TRANSMITTAL SHEET

To:	City of Mercer Island	From:	Erik Voris
Company:	Department Services – Building & Planning	Project:	Project 2101-202
Address:	9611 SE 36 Street Mercer Island, WA 98040	Date:	6/9/2021
		Regarding:	Correction Cycle#1

In addition to the transmitted documents, please refer to the specific responses to each plan reviewer's correction comments below.

ARCH SITE PLAN

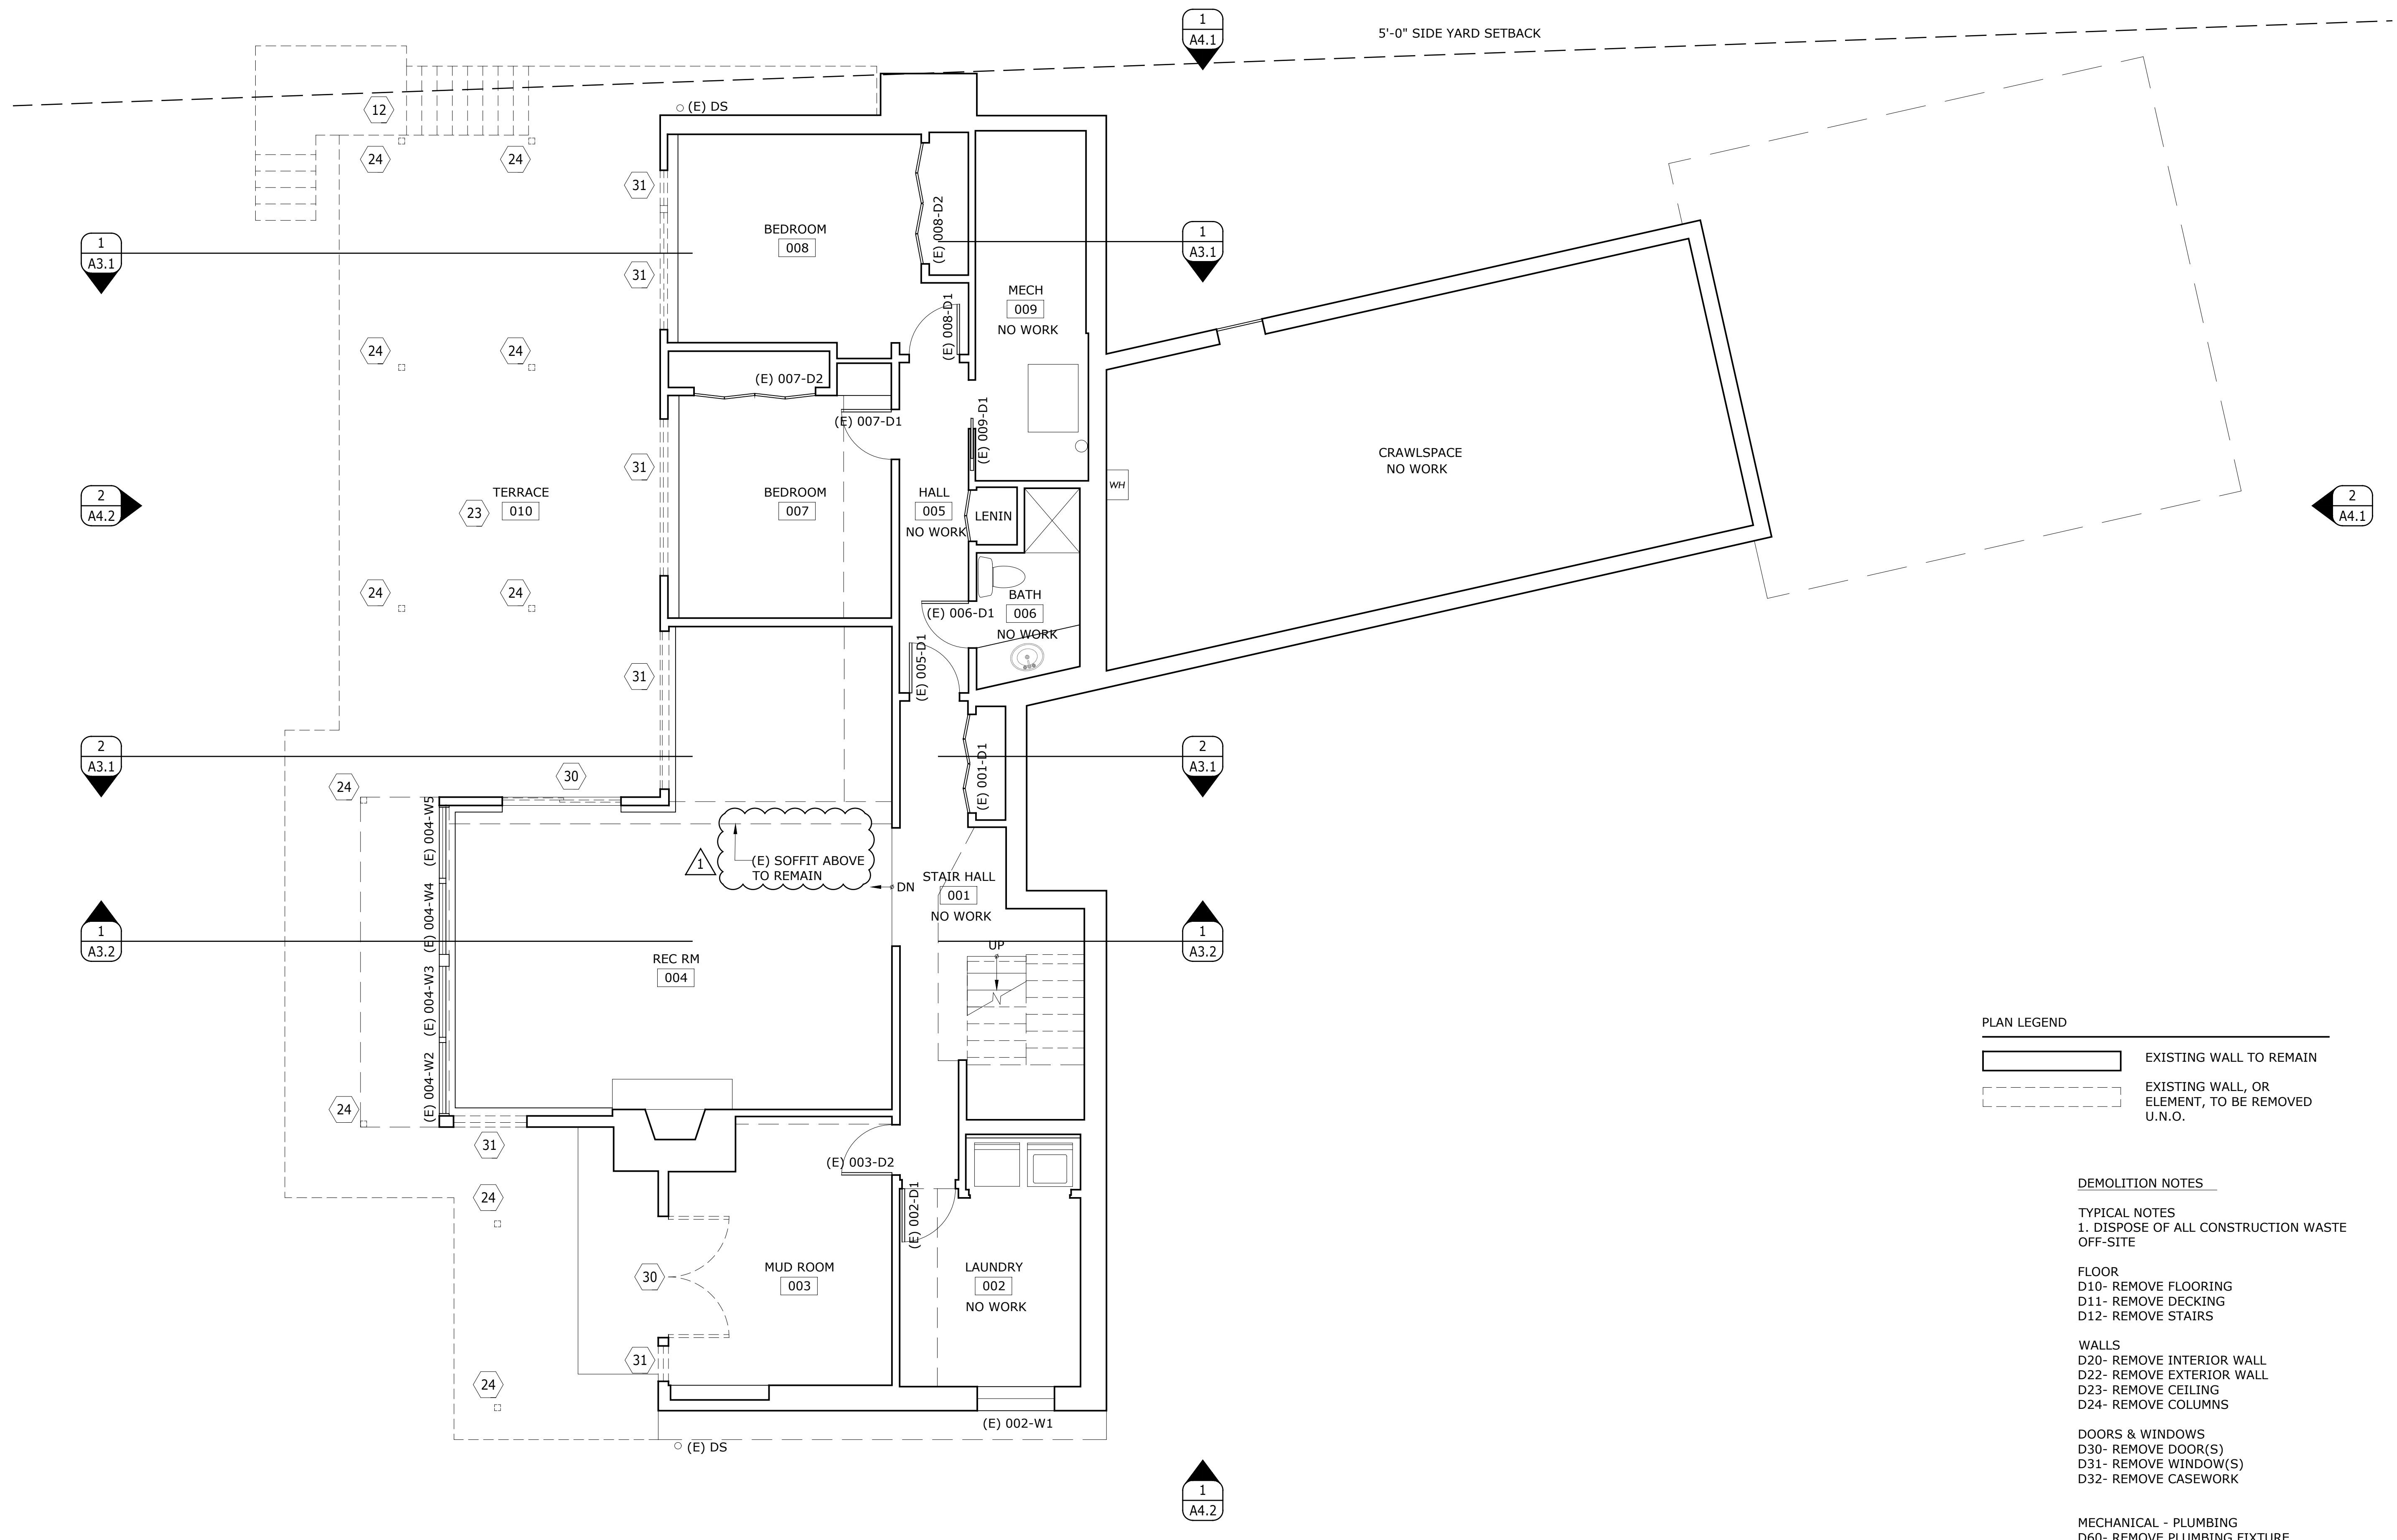
1. It appears a new driveway/construction access to the south of the house may impact onsite and adjacent trees. Provide an Arborist report for all trees in the area of construction including adjacent trees that may be impacted. And a tree protection plan as described in the following checklist.

1. The new backflow prevention valve at side sewer cannot be at the main which is under the water.

Via email correspondence on 4/5/21 John acknowledged an arborist report is not required and showing tree protection for on-site and adjacent trees along the driveway will resolve the issue.

See revisions on A1.1 Site Plan for the added tree protection along the driveway.

The new backflow prevention valve location has been moved further up line into the rear yard.

See revision on A1.1 Site Plan for new location.

AD2.1

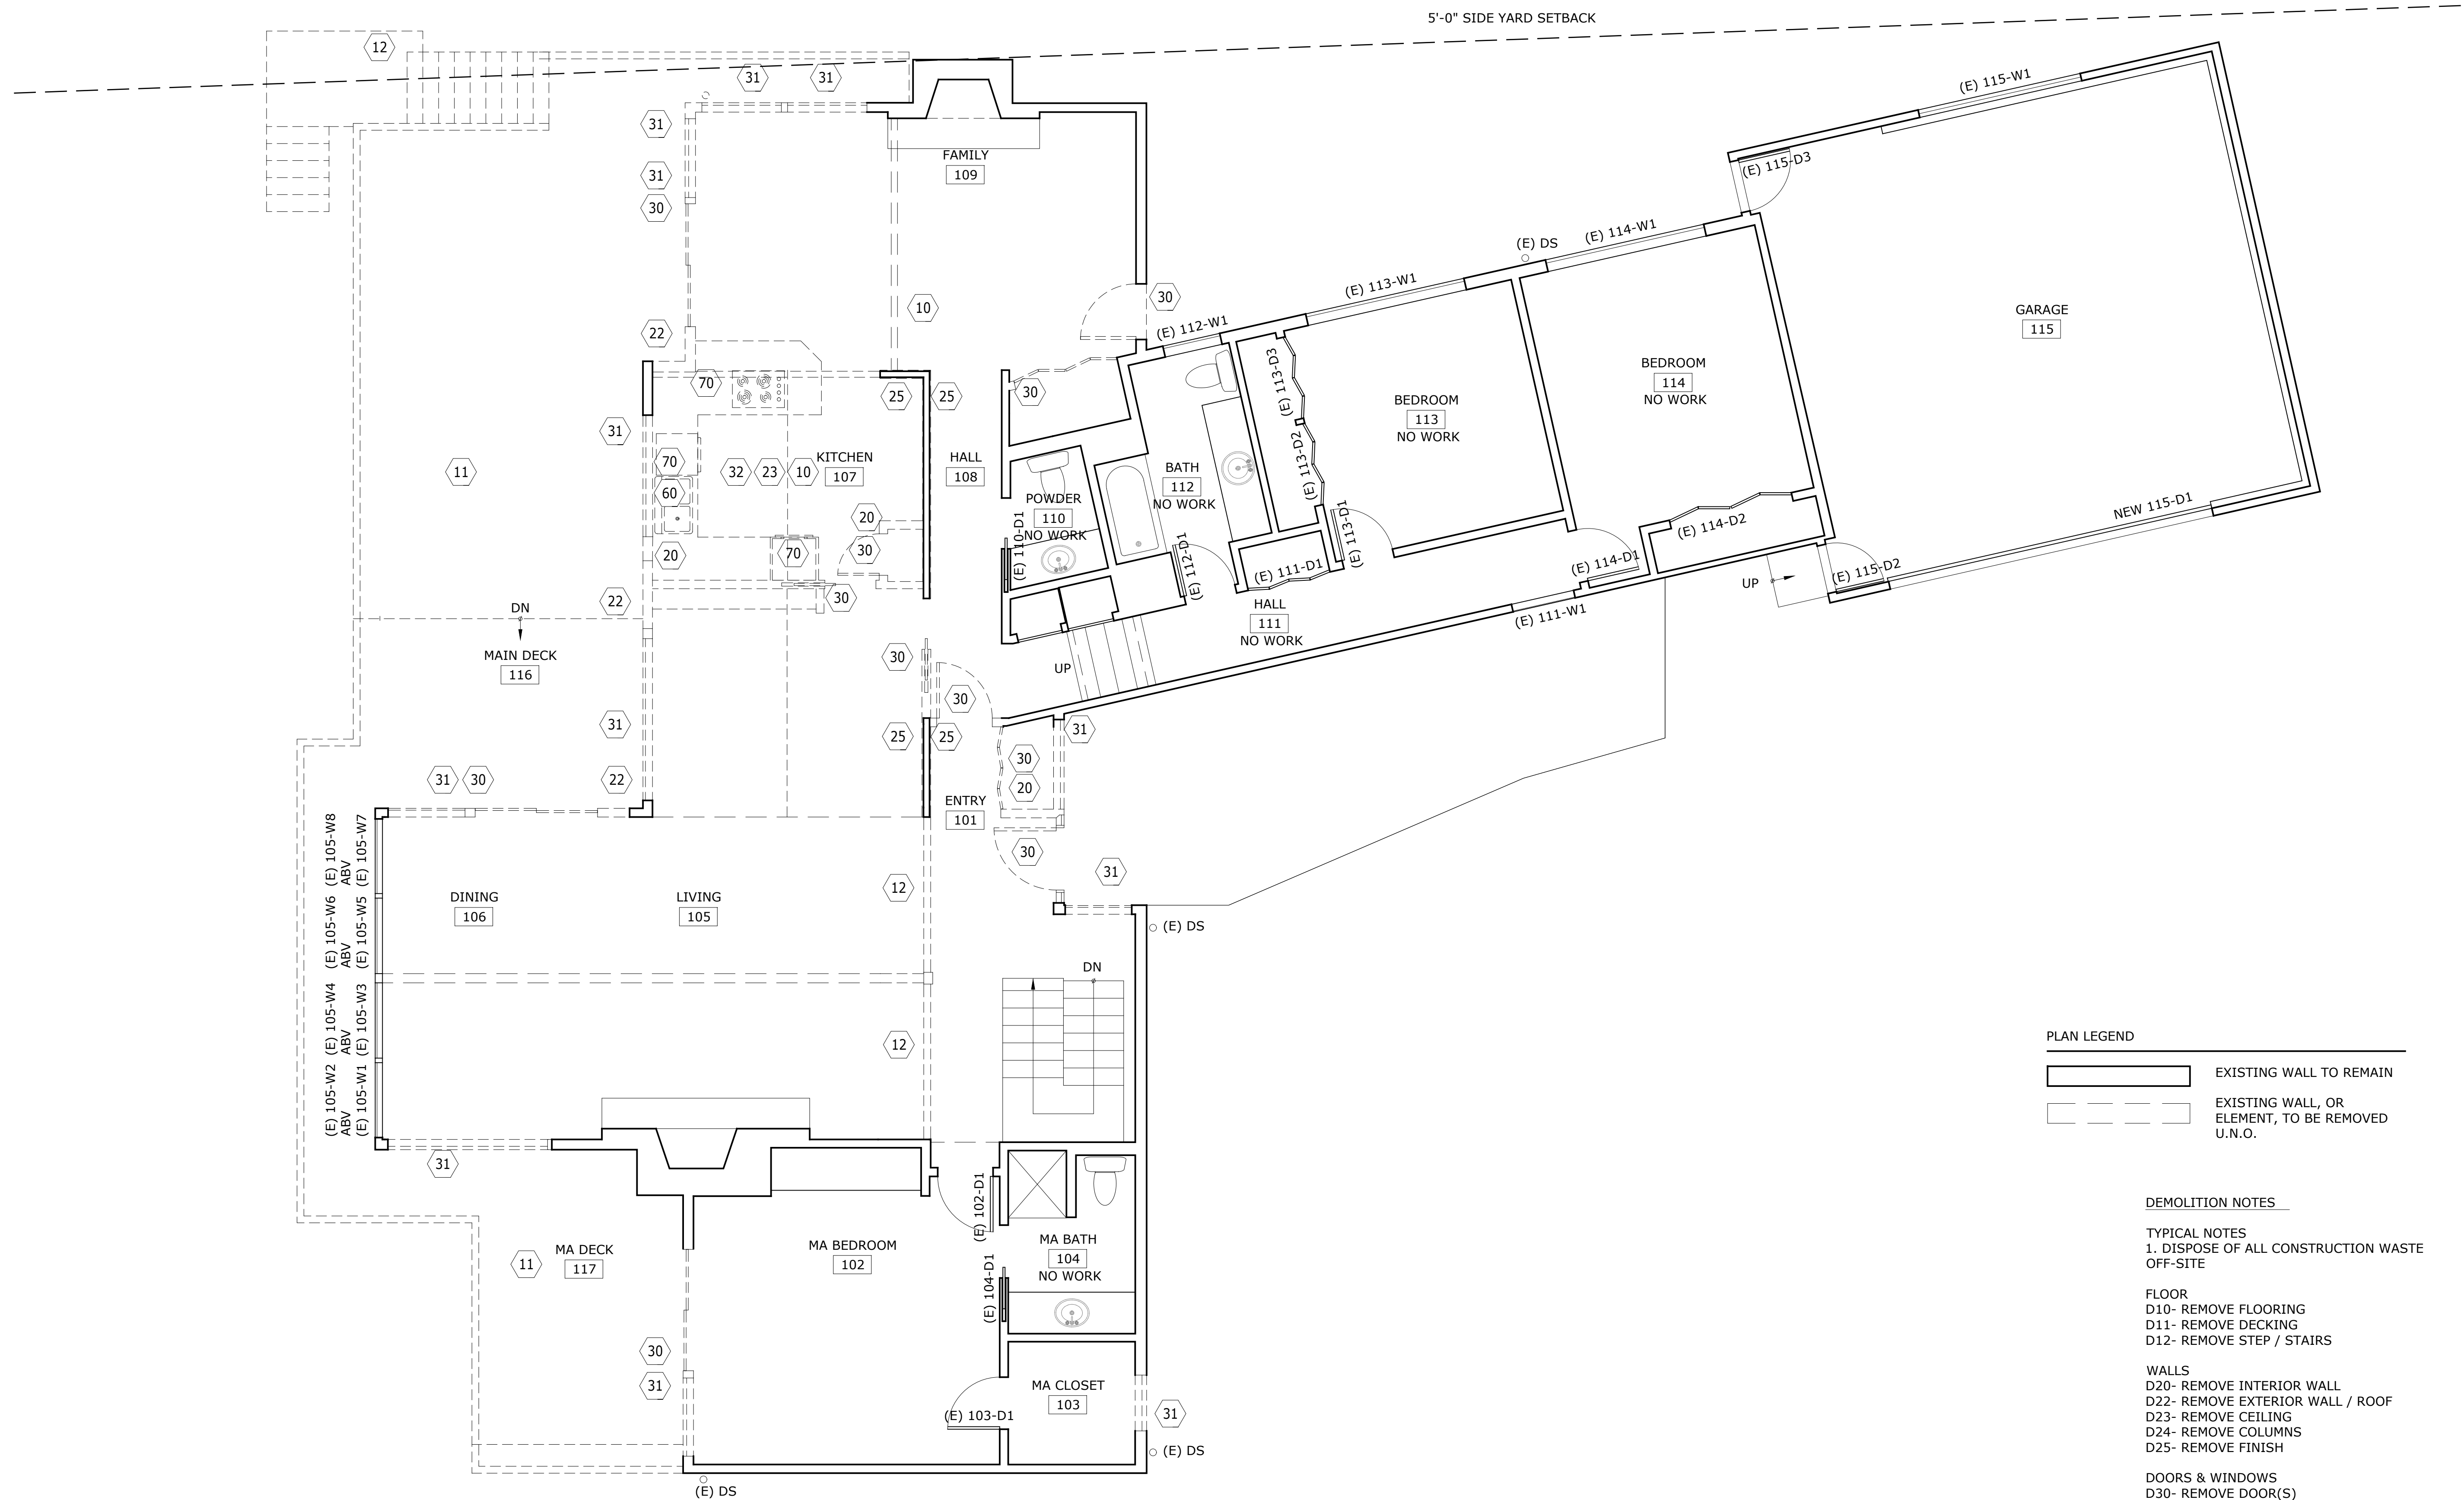
1. The Geotechnical Engineer is required to provide a written statement that the project documents have been reviewed for conformance to the geotechnical recommendations.
2. Please clarify what the elements are that are being removed. Is this a soffit? Wall? Steps?
3. CO detector required outside the bedroom(s).

- 1 - The Geotech engineer has provided a plan review letter with minimal risk statement.**
- 2 - The elements are existing soffits to remain. See AD2.1 for clarification.**
